WEST SUSSEX COUNTY COUNCIL CONSULTATION

TO:	Arun District Council FAO: Simon Davis
FROM:	WSCC - Highways Authority
DATE:	8 June 2020
LOCATION:	13-17 Abbeyfield Richmond Avenue Bognor Regis PO21 2YE
SUBJECT:	BR/114/20/PL Conversion of existing vacant residential care home into 10no. flats.
DATE OF SITE VISIT:	n/a
RECOMMENDATION:	No Objection
S106 CONTRIBUTION TOTAL:	n/a / £ See below for breakdown.

DRAWING
CONSTRUCTION PLAN
DRAWING No
313/07
REVISION
SCALE 1:50
DATE APRIL 20
DRAWN LA
CHECKED

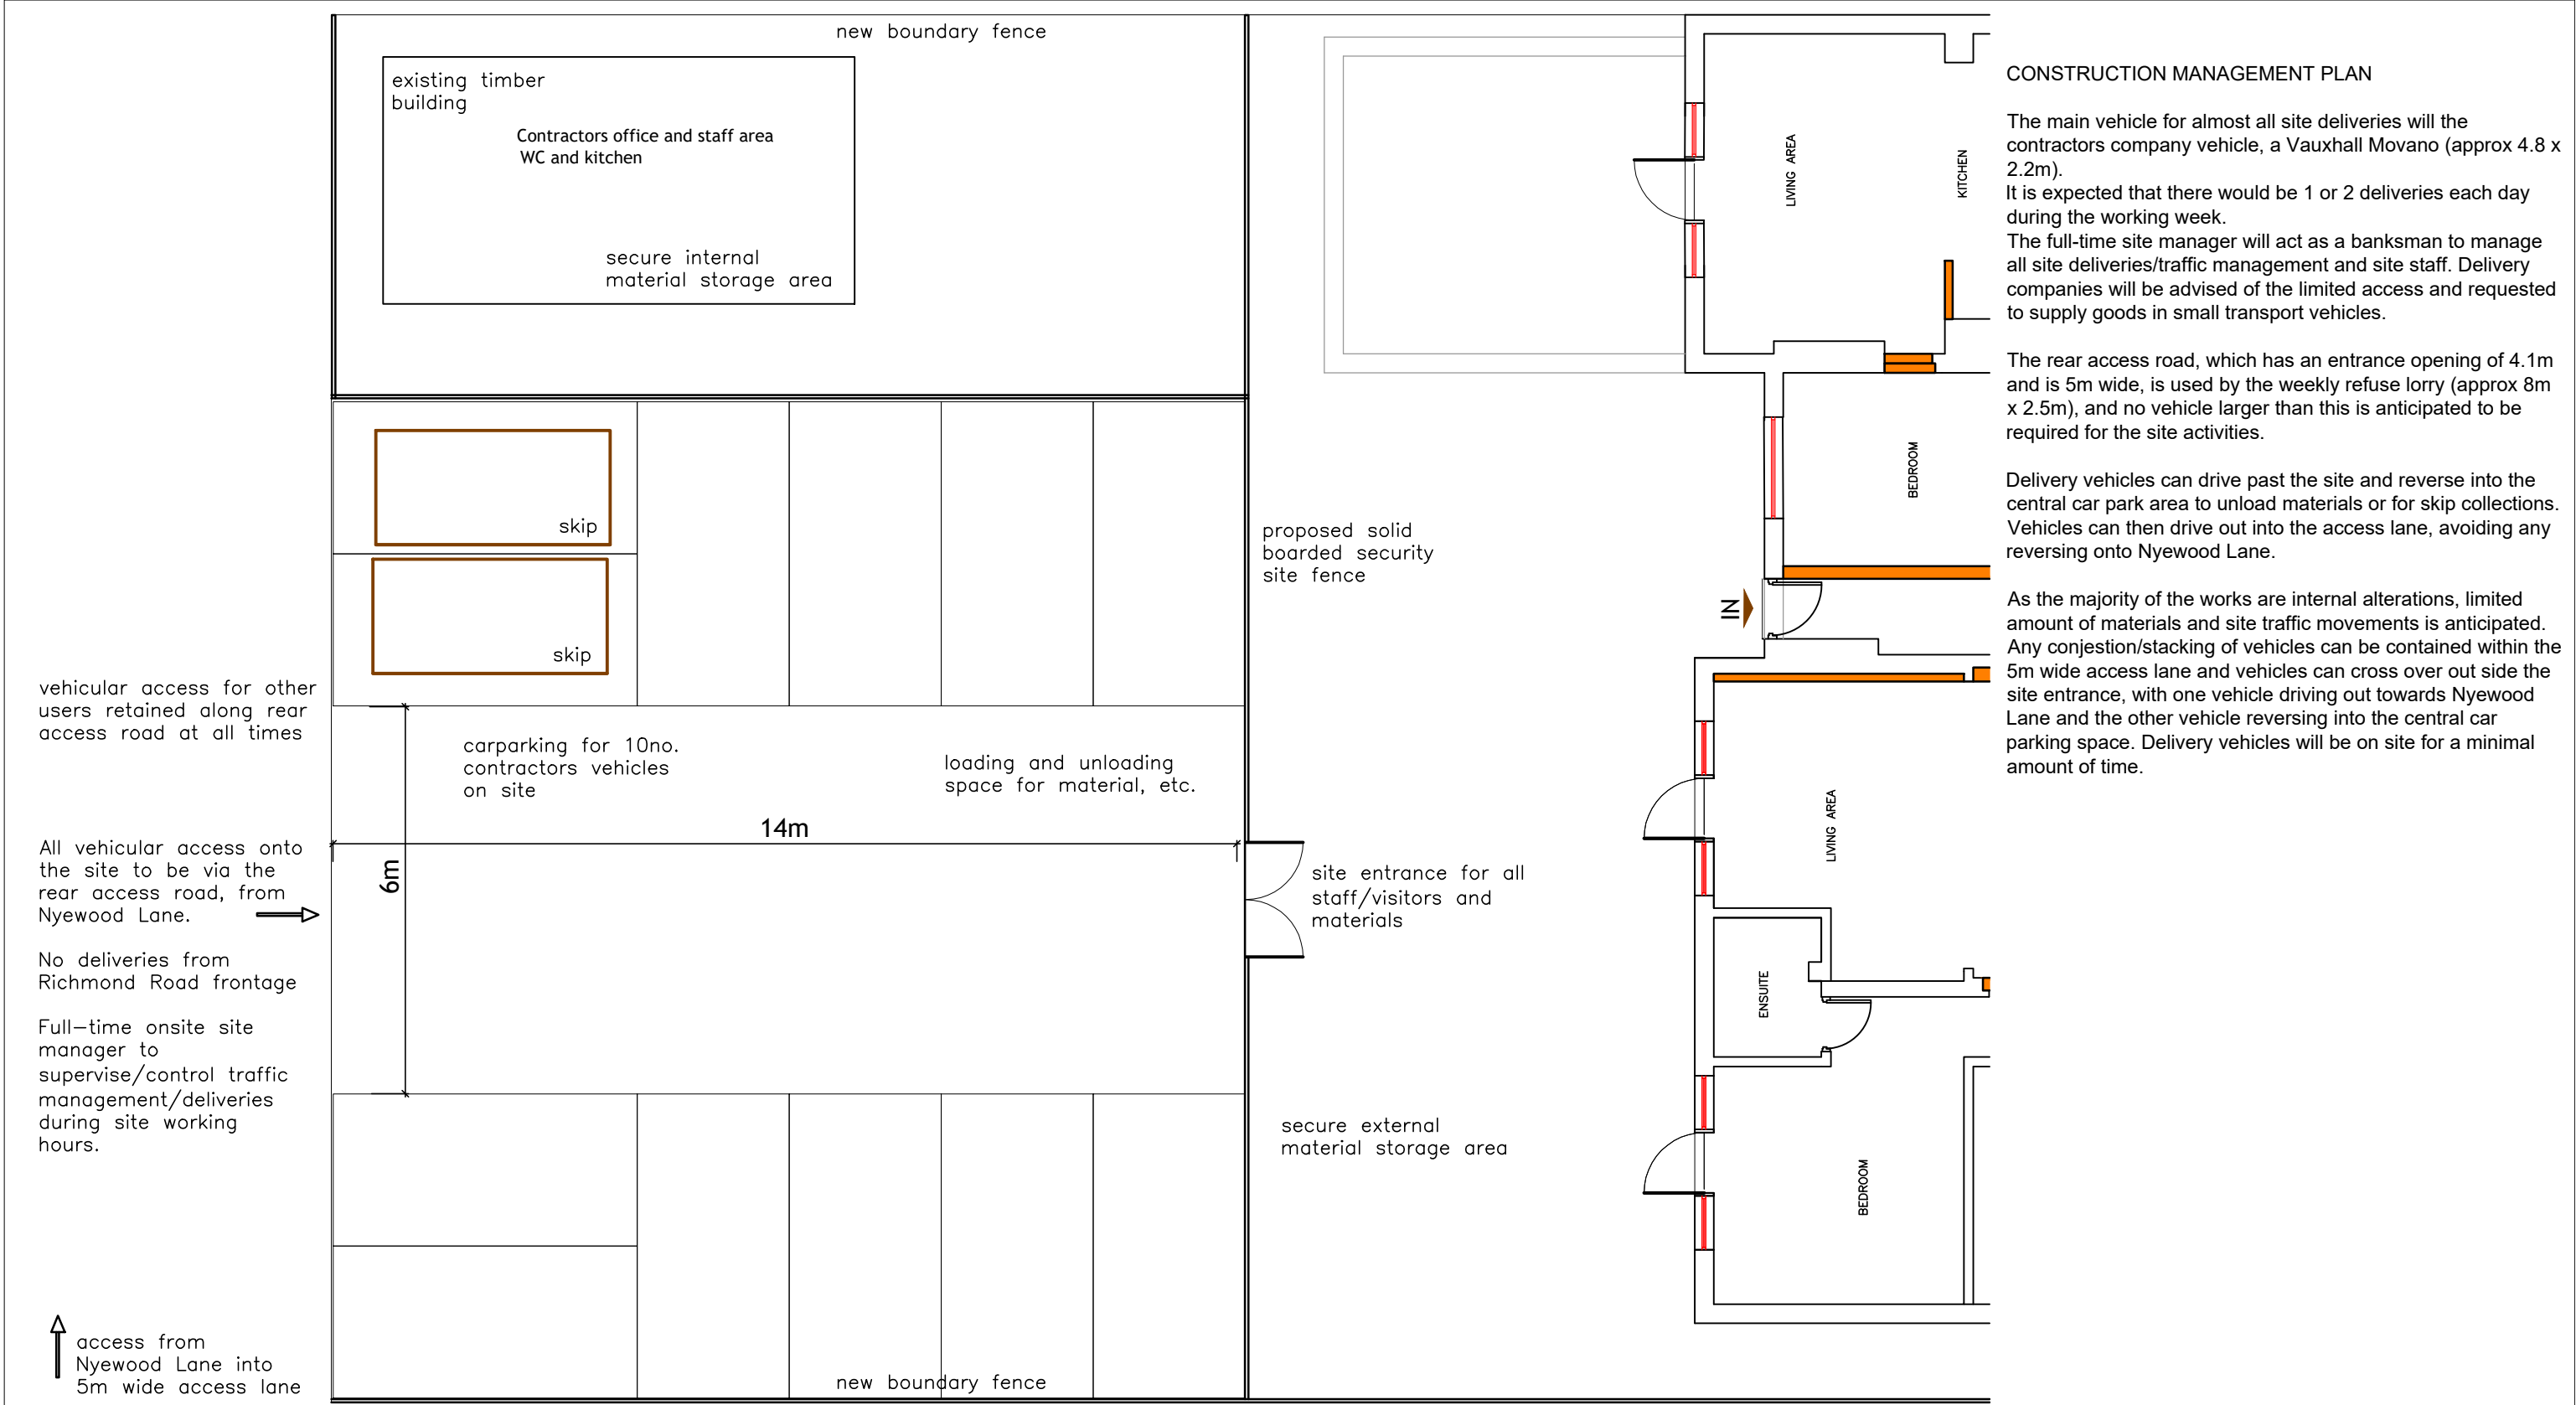
During the renovations the rear car park will also be used as the construction site and compound. This is shown in the construction management plan (313/07). The size of vehicles used will mainly be transit style vans, with the occasional larger deliveries which will be

SITE PLAN 1:500

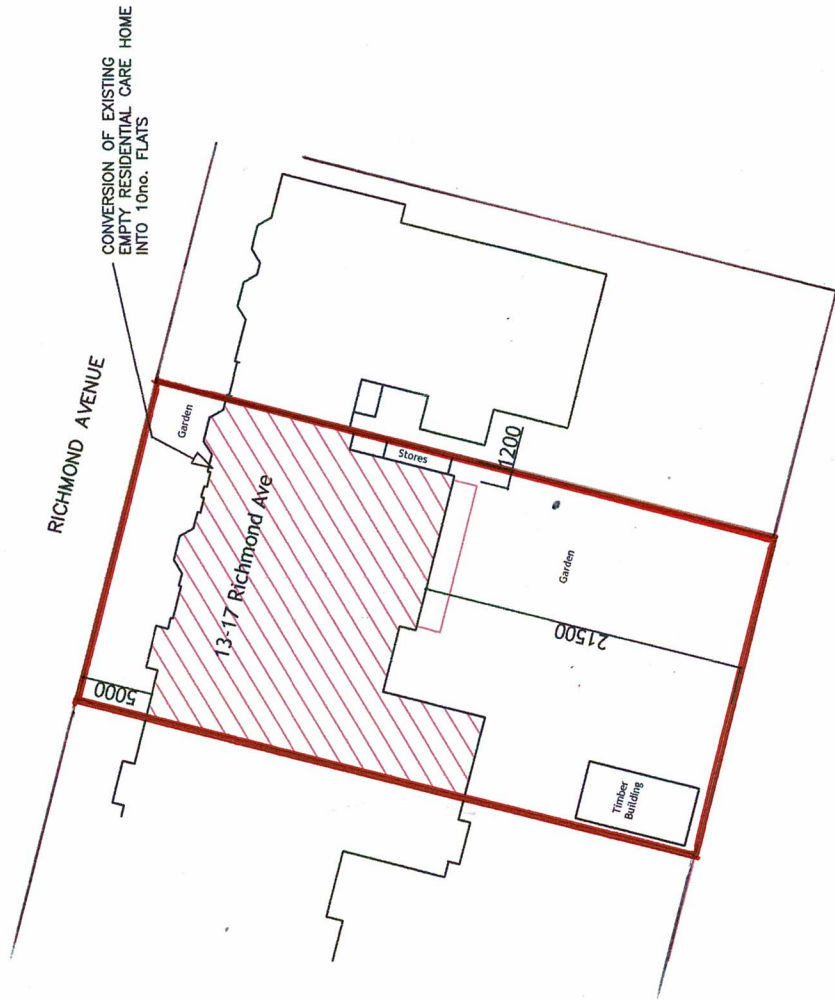
The car park will have a 6m wide access; and create 12 spaces each at 2.4m x 4.8, as per manual for streets guidance. Ideally 1 space should be provided for disabled use in line with MFS. The access into the carpark is wide, at 6m this will allow a car to enter and exit simultaneously should this occur.

Cycle parking for each flat should be provided which is secure and covered as per NPPF guidance.

No part of the development shall be first occupied until the car parking has been constructed in accordance with the approved site plan. These spaces shall thereafter be retained at all times for their designated purpose.

No part of the development shall be first occupied until covered and secure cycle parking spaces have been provided in accordance with plans and details submitted to and approved by the Local Planning Authority.
